CITY OF ALBUQUERQUE

March 24, 2023

Re: Harper Apartments/ PHASE 5
6100 Harper Dr. NE
30-Day Temporary Certificate of Occupancy
Transportation Development Final Inspection
Architect's Stamp dated 09-15-20 (E18-D016)
Certification dated 03-15-23

TRAFFIC CIRCULATION LAYOUT

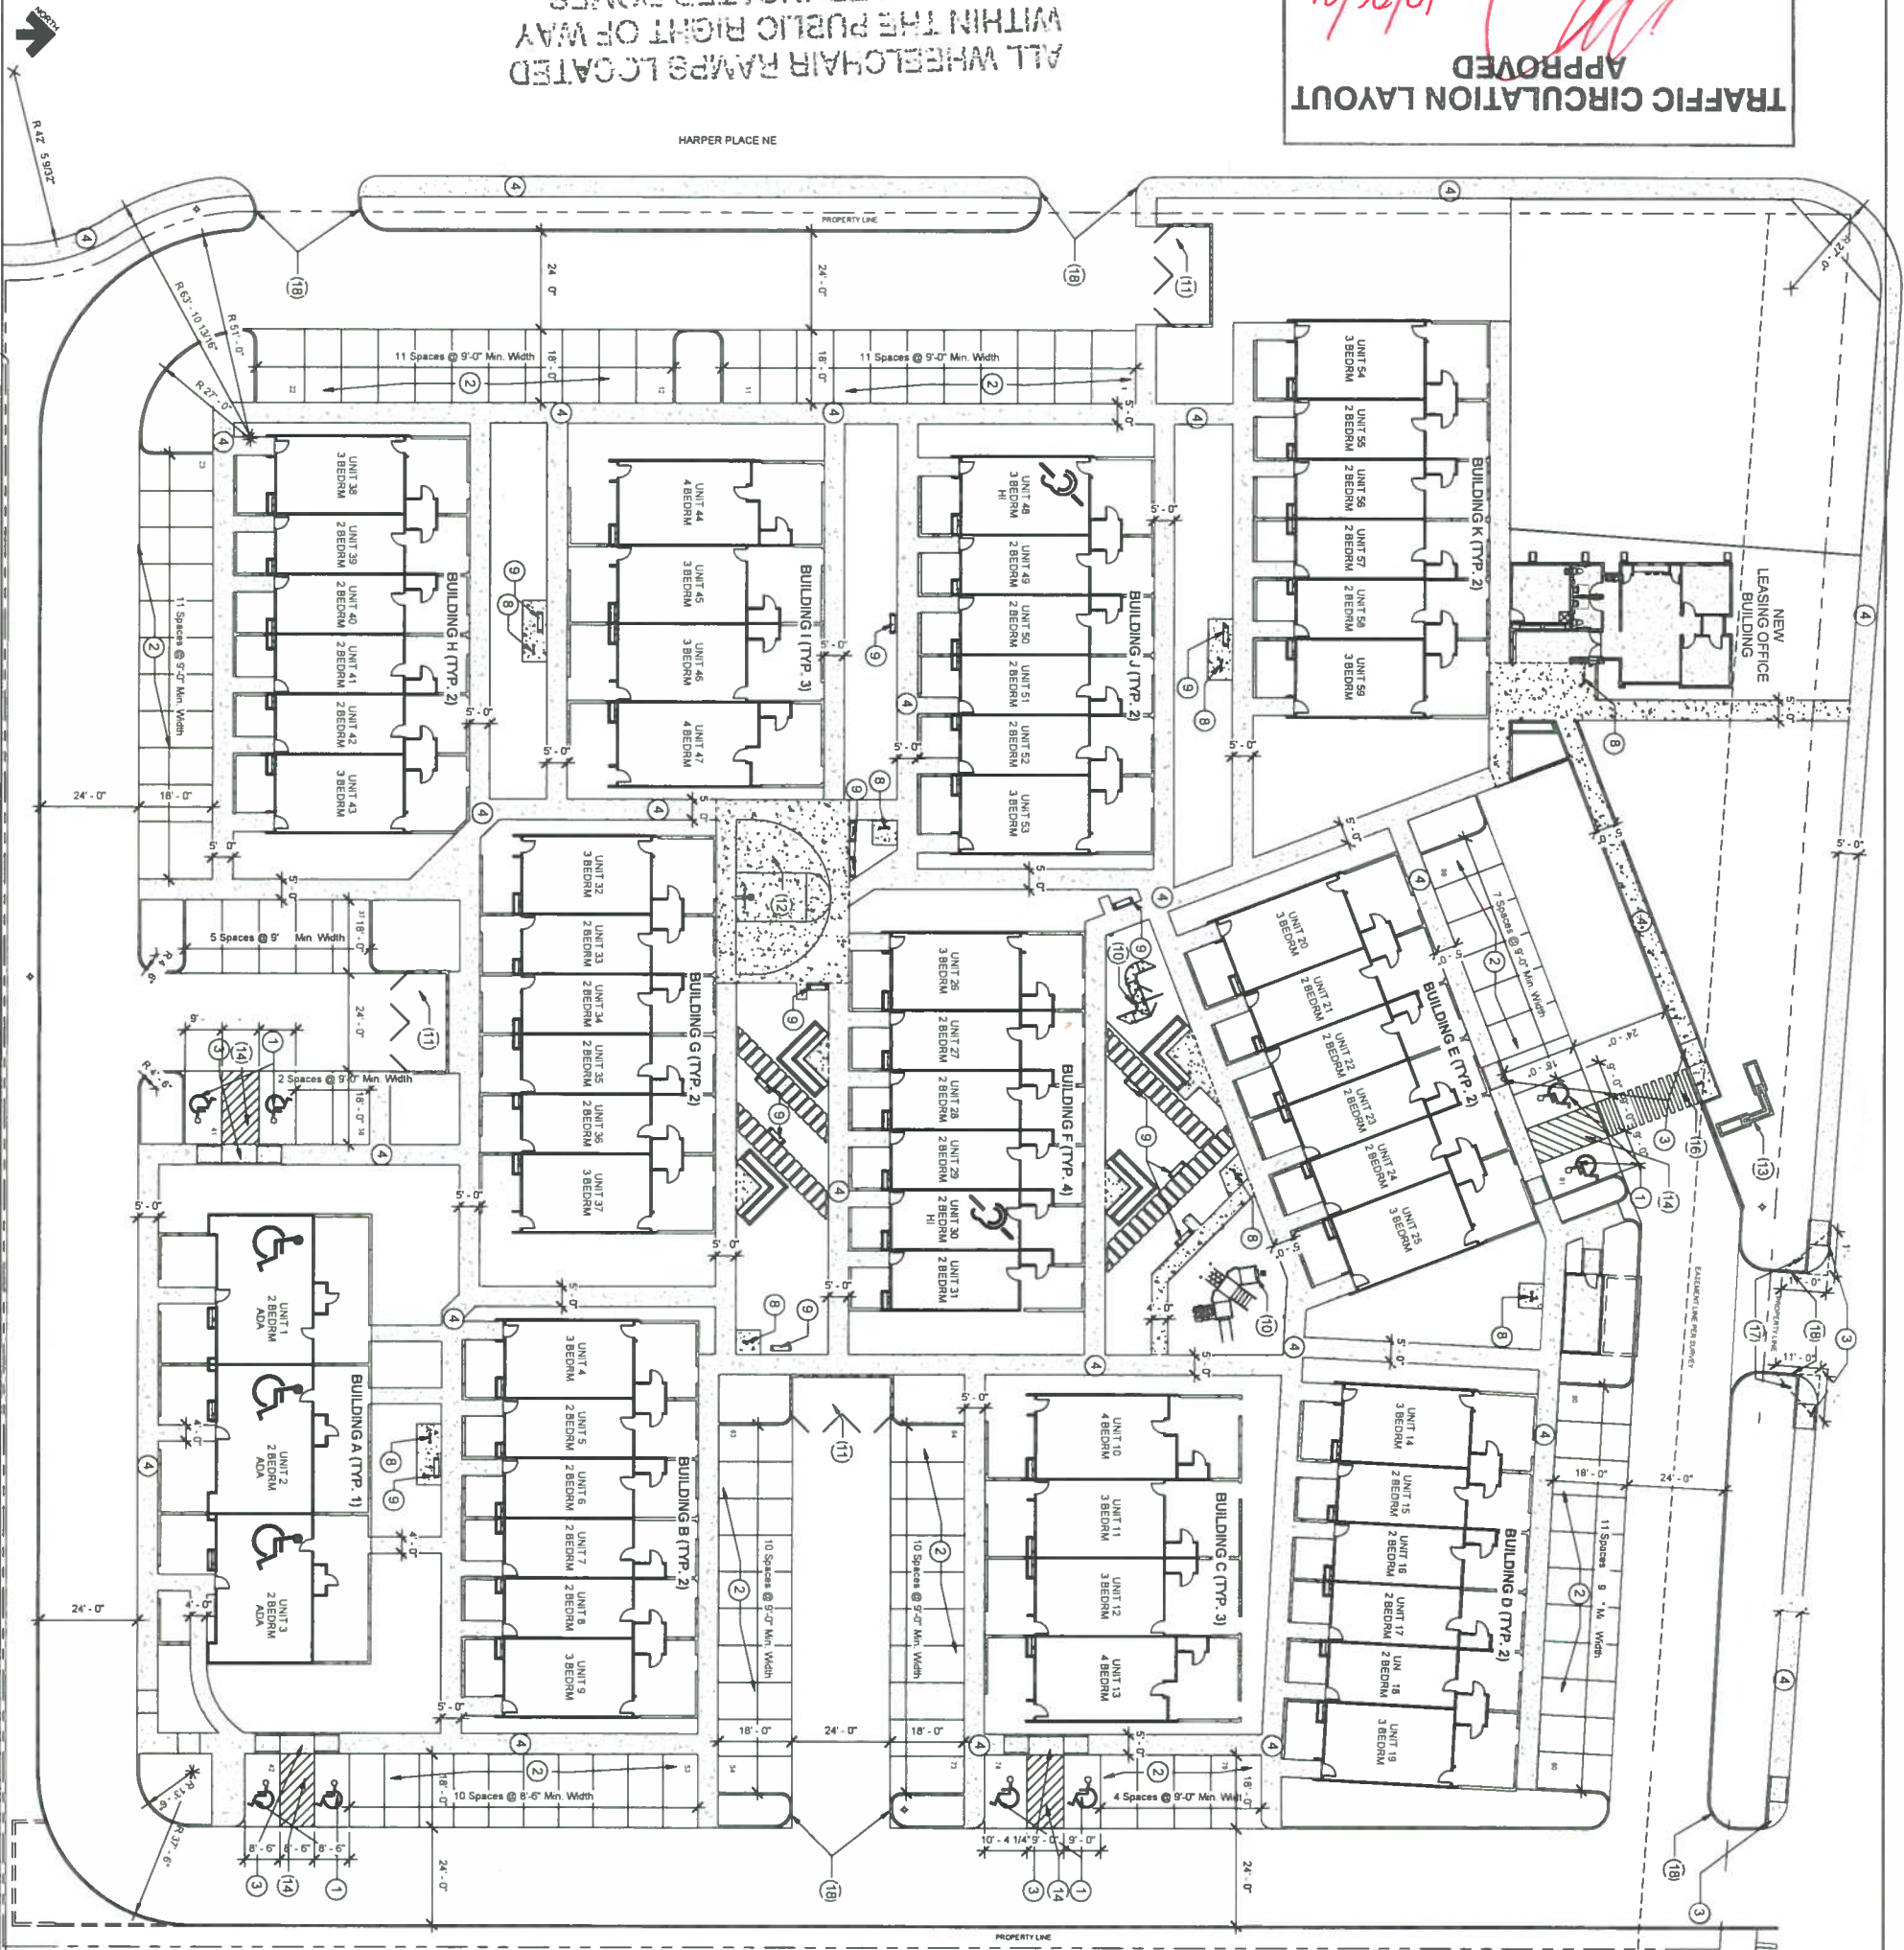
- Please provide an As-Built site plan. Red mark the approved site plan to show the new location of the Basket Ball Court, and the Dumpster at the corner of building H. See attached pictures.
- Please fix the pedestrian pathway behind building H.
